Application no: H02-0478-14

Description: Proposed fascia sign

Location: SHOP
2 WEST STREET
CROWLAND
SPALDING
PE6 0ED
PE6 0ED

Amendment: Reduction of lights from 4 to 2, removing the 2 outer
lights from the original plan (dwg. no. Ver1.01)

Scale 3cm:1m
Ver1.01 17/04/2015

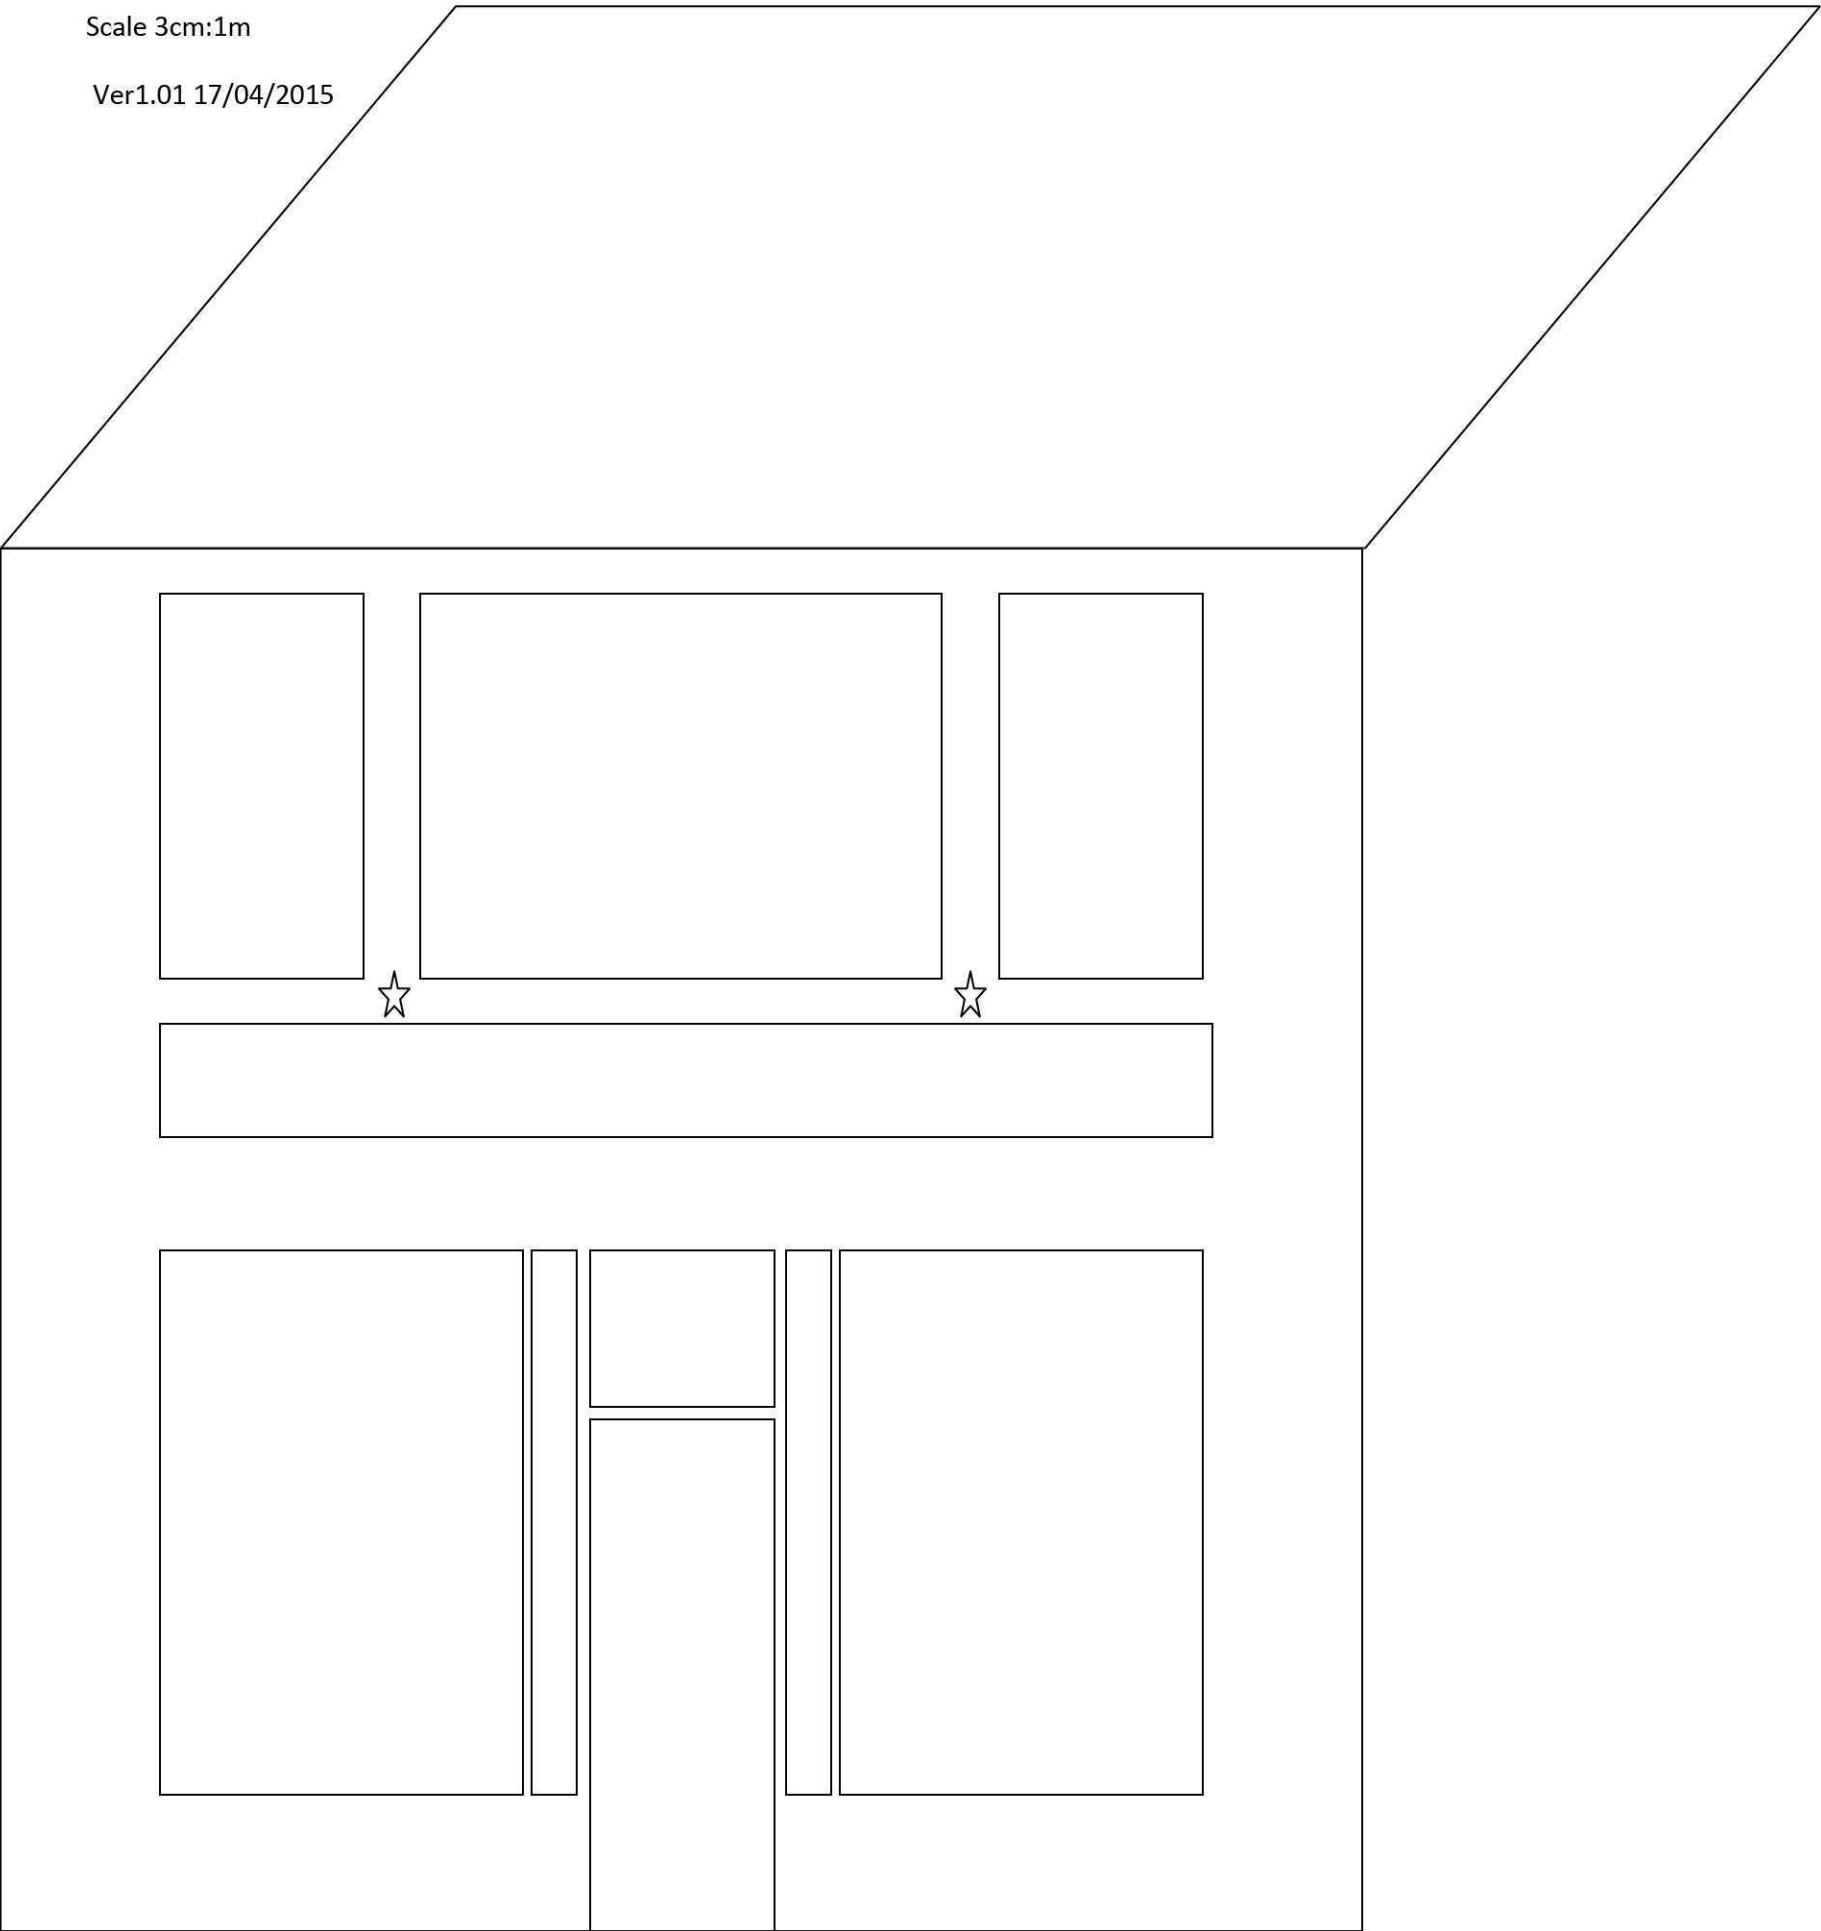
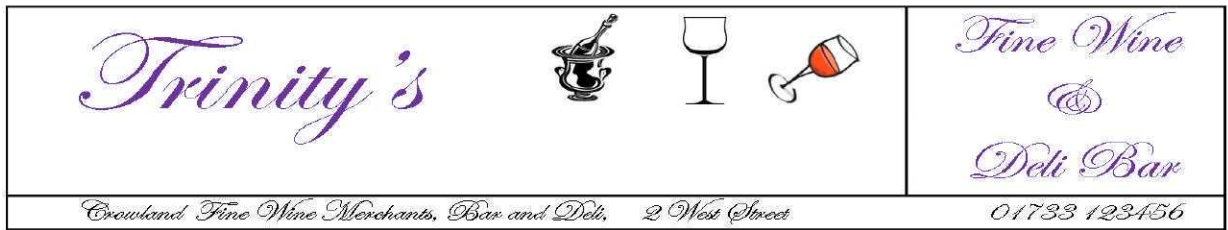
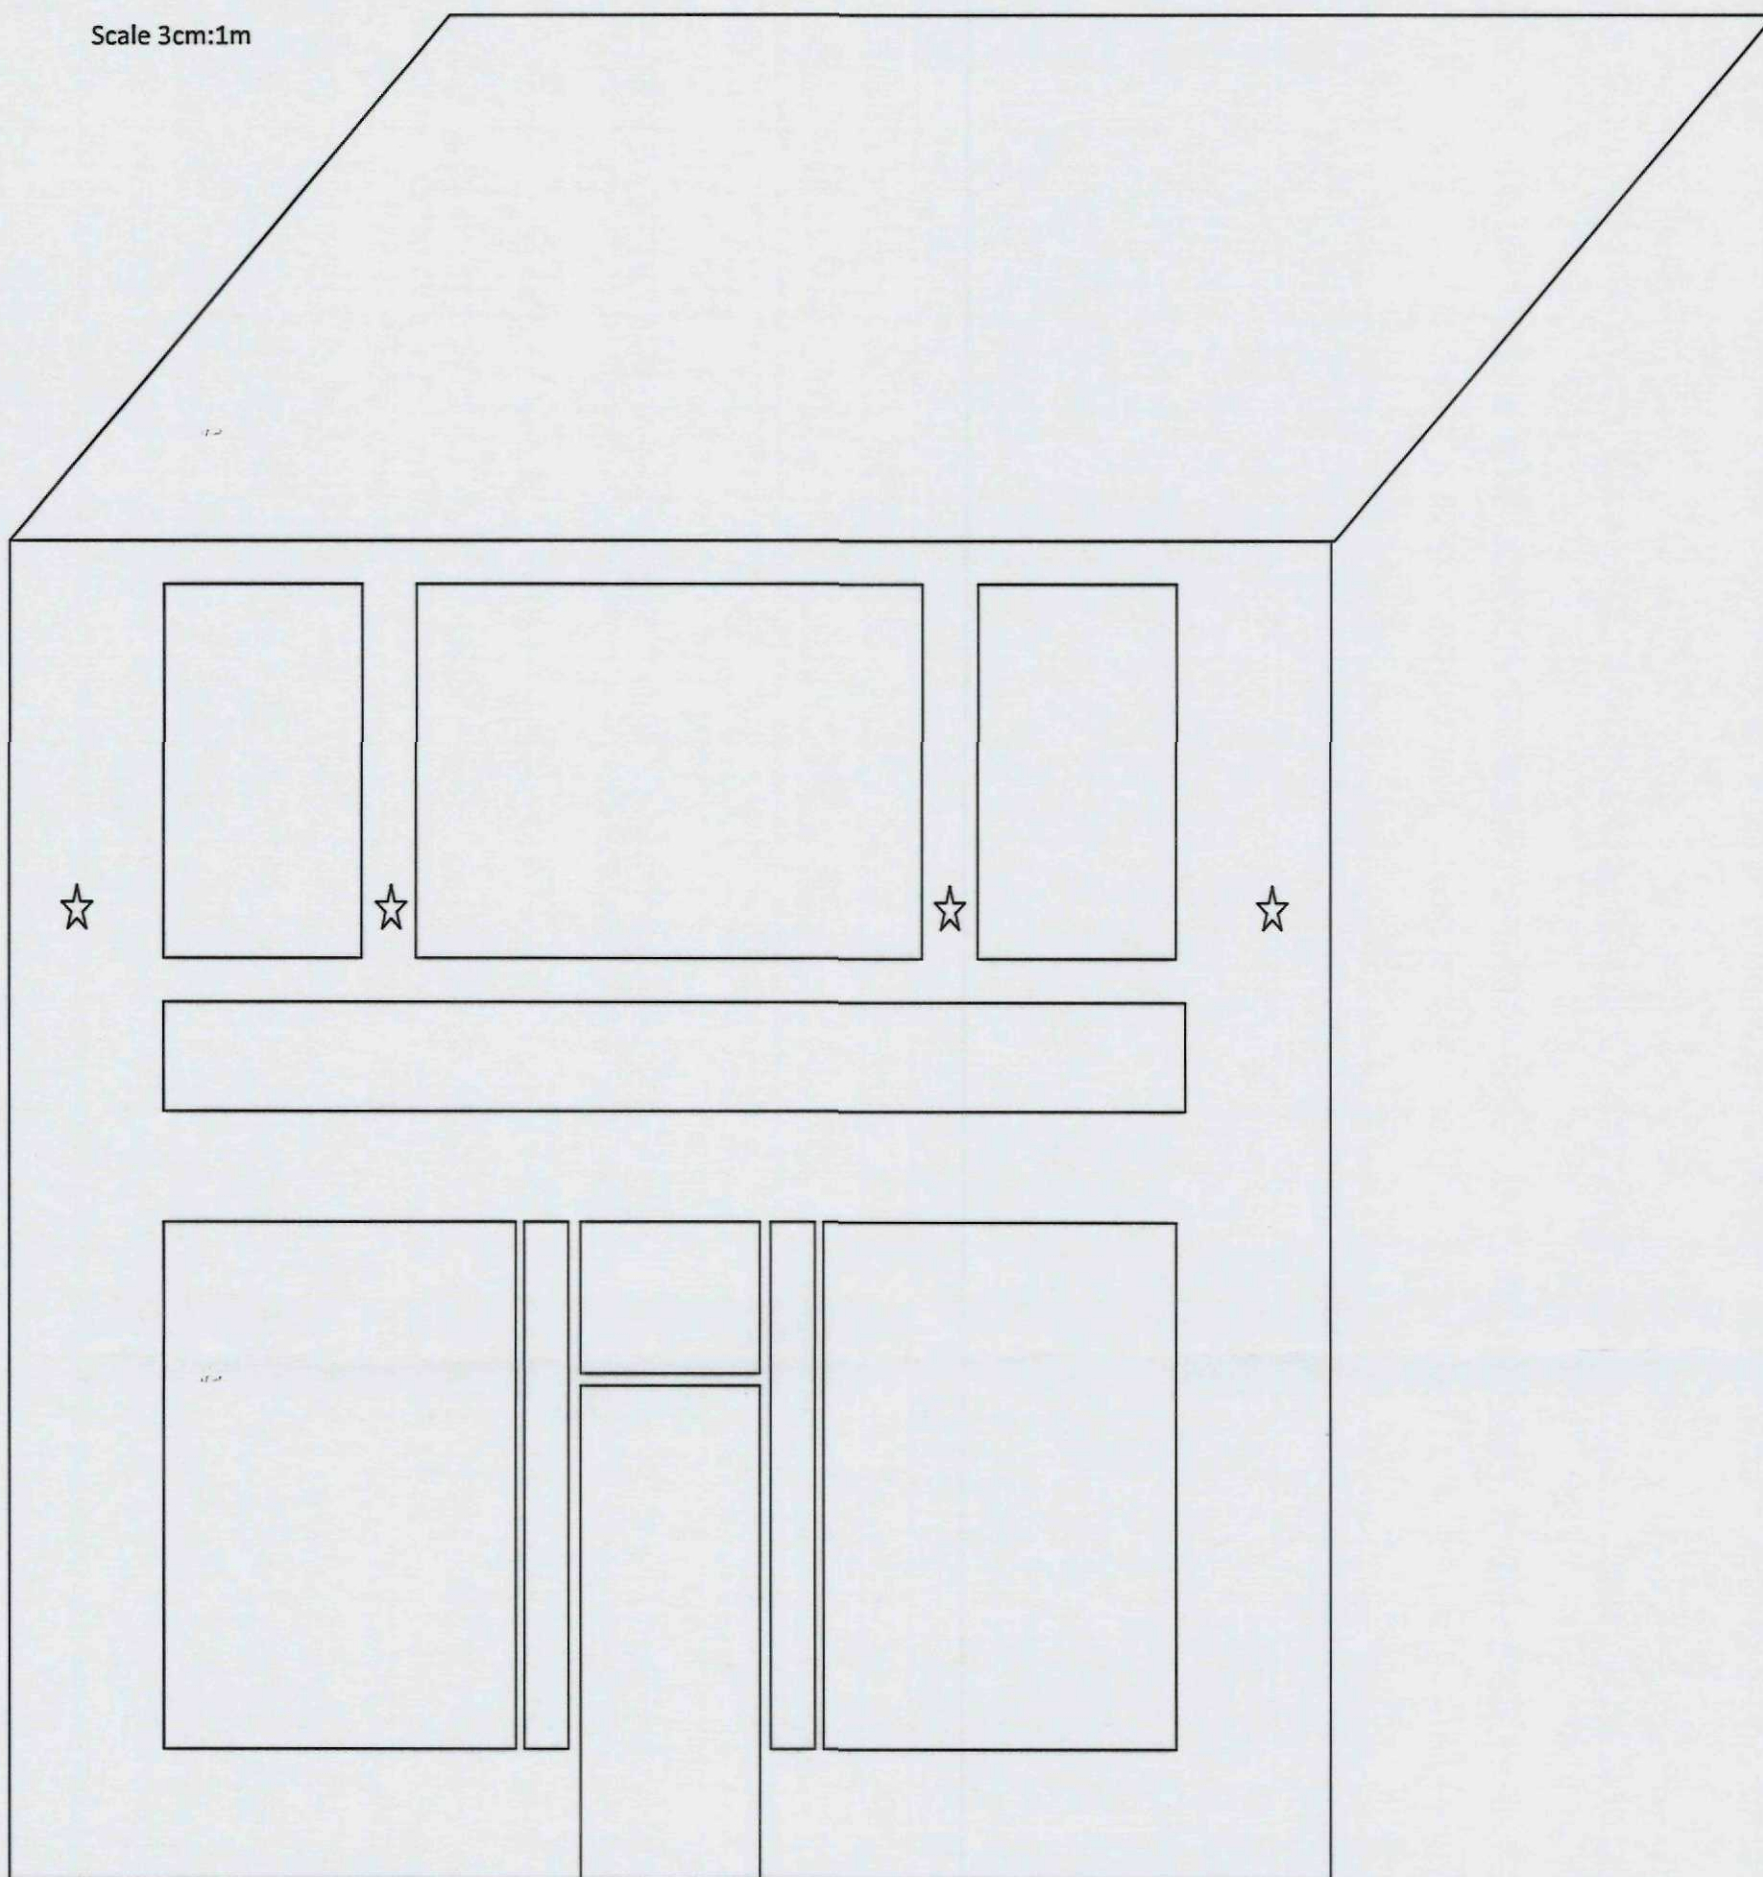
I have spoken to a colleague concerning the proposed amendment to your scheme. There is some paperwork that needs to be completed. It would also be beneficial to have a copy of your plan submitted with the two outside lamps deleted. If you could date the plan with todays date, that would be useful.

Description Reduction of lights from 4 to 2, removing the 2 outer
lights from the original plan (Dwg no. Ver1.01)Long
Description
